Consultation Response from KC, Lead Local Flood Authority
2023/93236 Pentlands, New Mill Road, Holmfirth, HD9 7LN
Discharge conditions 4 (Internal Estate Road Details), 5 (Parking Bay Surfacing & Drainage), 9 (Temporary Waste Measures), 11 (Surface Water Drainage Details), 12 (Overflow Event Scenario), 13 (Separate Forms of Drainage Details), 15 (Temporary Drainage Measures), 22 (Ecological Enhancement Plan) on previous permission 2020/91896 for demolition of existing dwelling and erection of 15 dwellings with associated access and external works
Date Responded: 12th March 2024 Responding Officer: Paul Farndale Responding Ref:

Condition 11 – Drainage Details

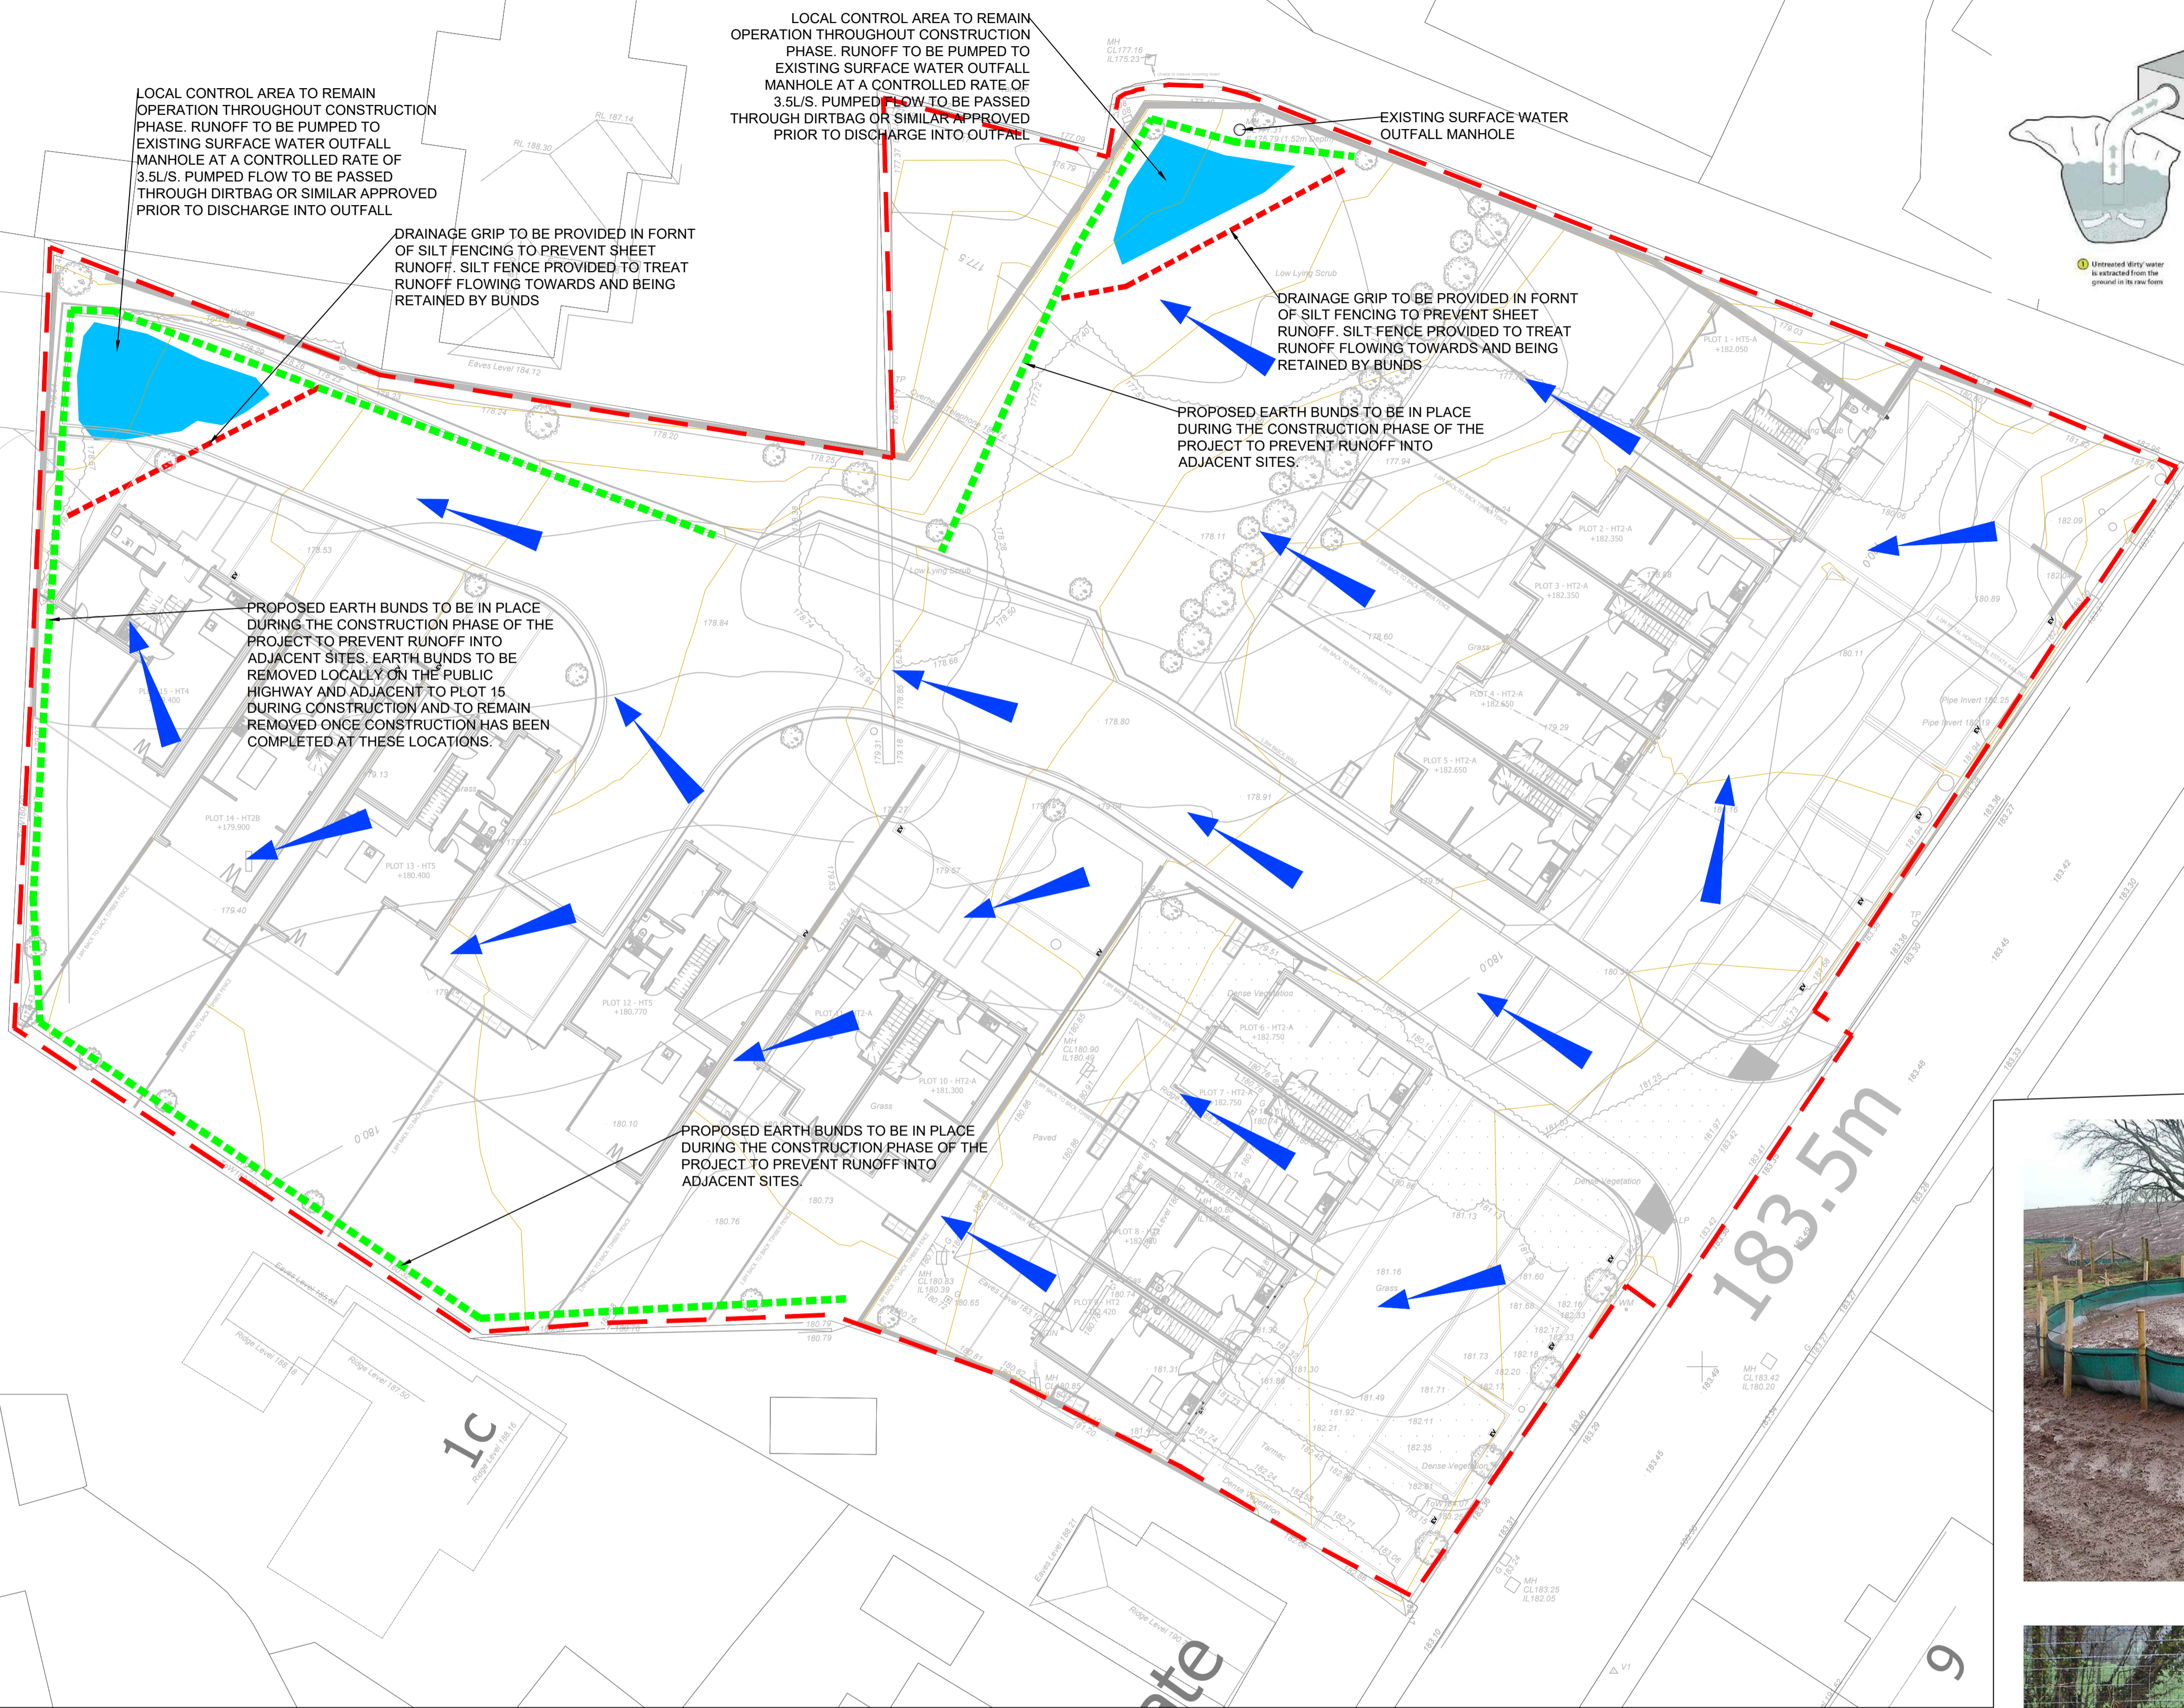
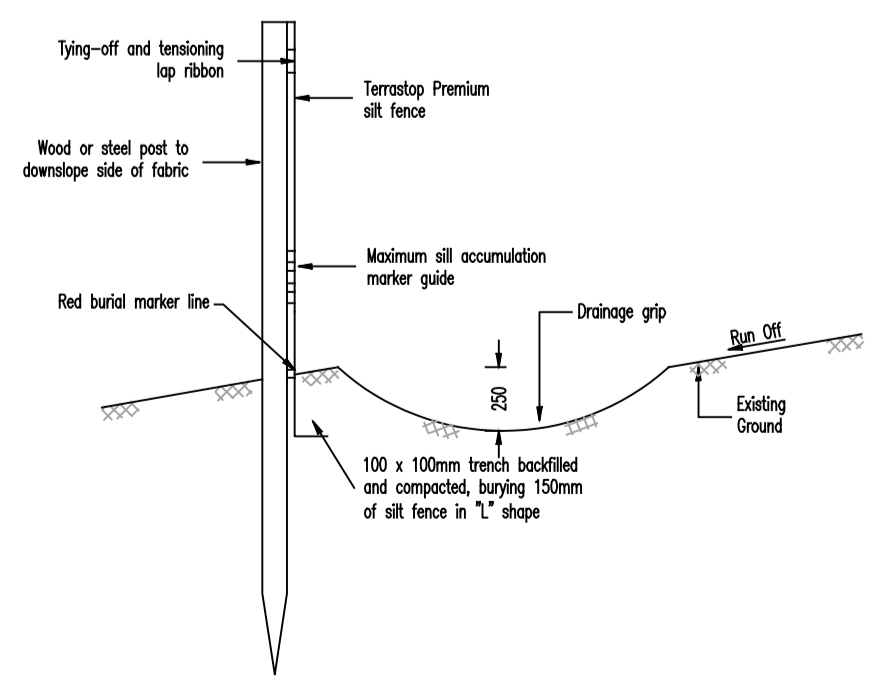
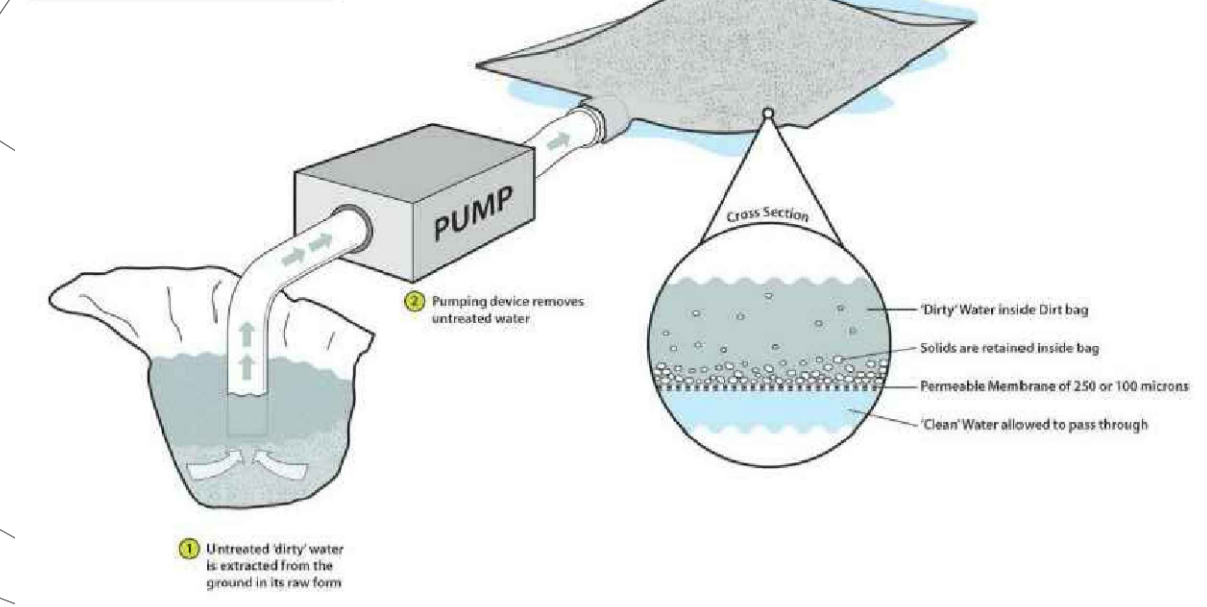
No additional information has been submitted. Our previous comments stand.

Unfortunately, this condition can NOT be discharged at this moment in time. Due to commencement of works on site we feel we must escalate the issue of adequate construction phase (temporary) drainage plans to our enforcement team.
